Please ask for: Nicola Moore
Email: nicola.moore@arun.gov.uk
Telephone: Ext 37944
Our Ref: A/33/20/CLP
Your Ref:
Date: 11th March 2020

Lawful Development Certificate for a Proposed Use or Development

Development: Lawful development certificate for a proposed single storey rear extension and roofing sun tunnels.
Location: West End Cottage Roundstone Lane Angmering BN16 4AX

Drawing
Proposed Elevations

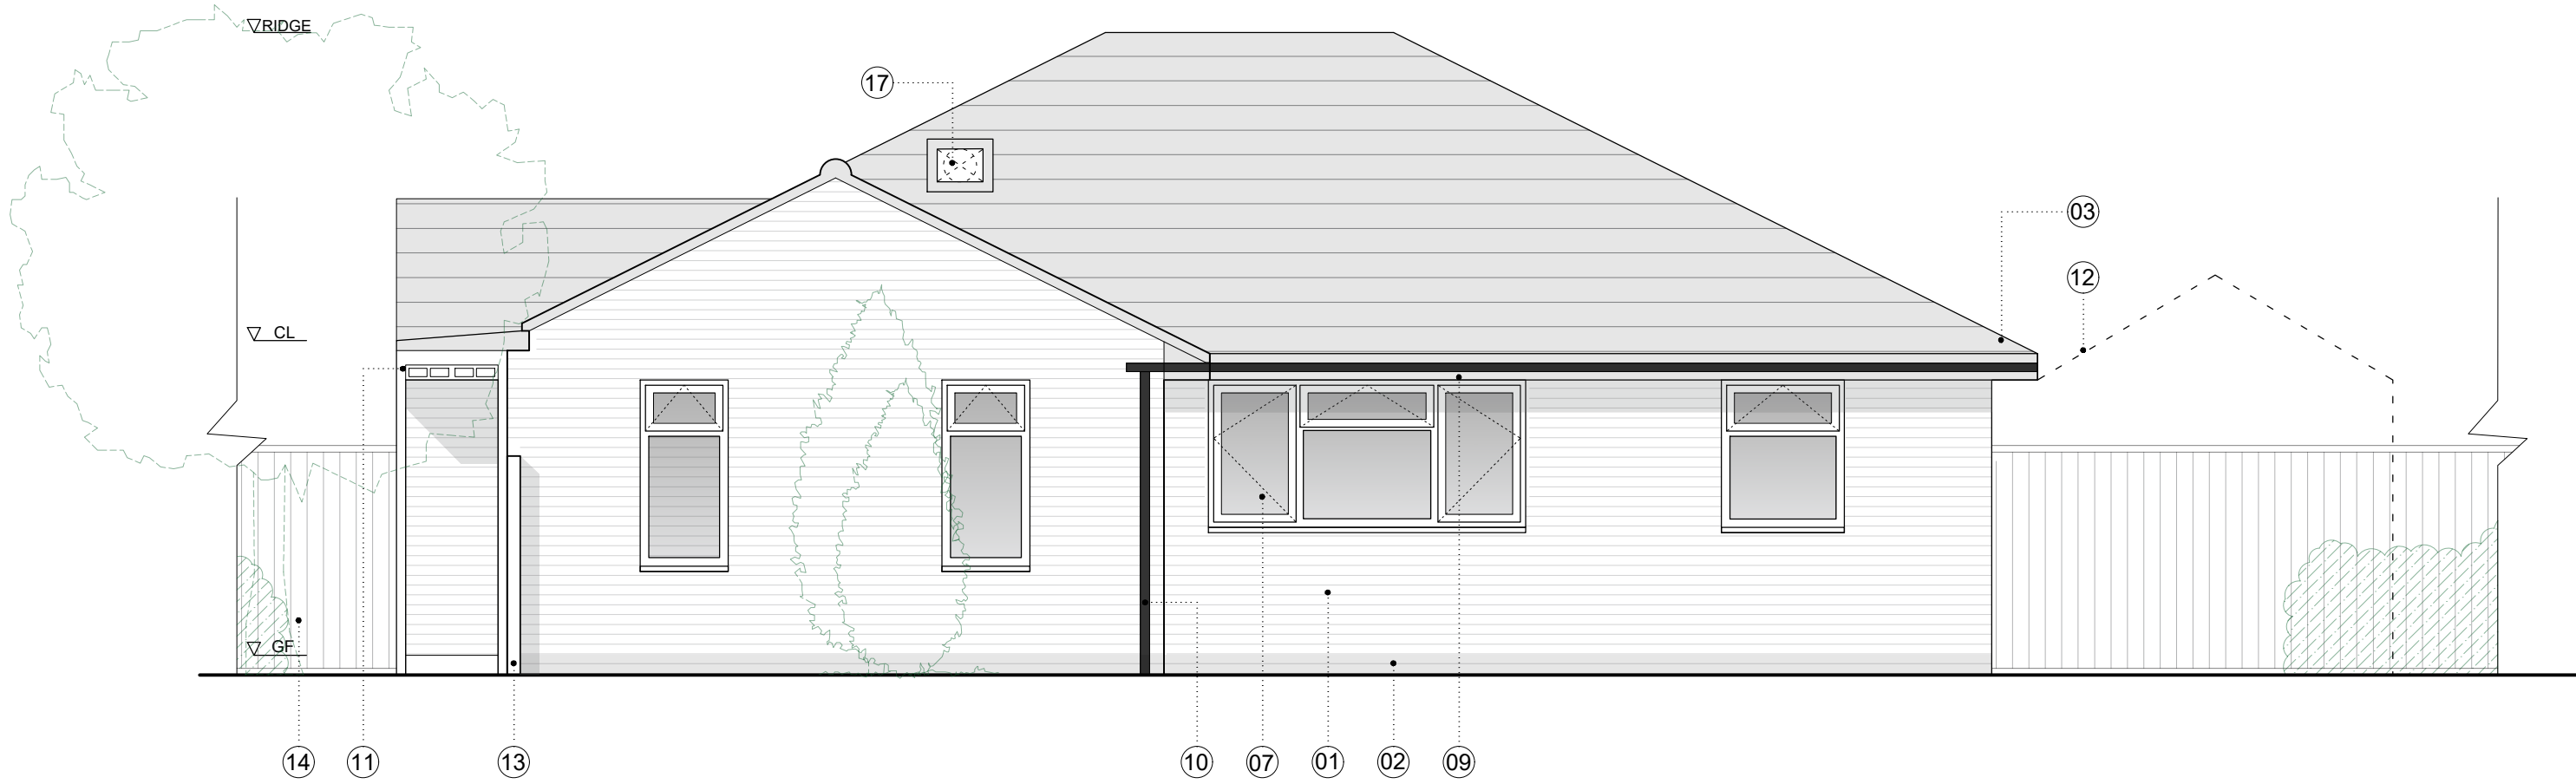
Elevations

Please amend the proposed elevations to show the roofing sun tunnels. Further details can be found in the Validation Requirements List.
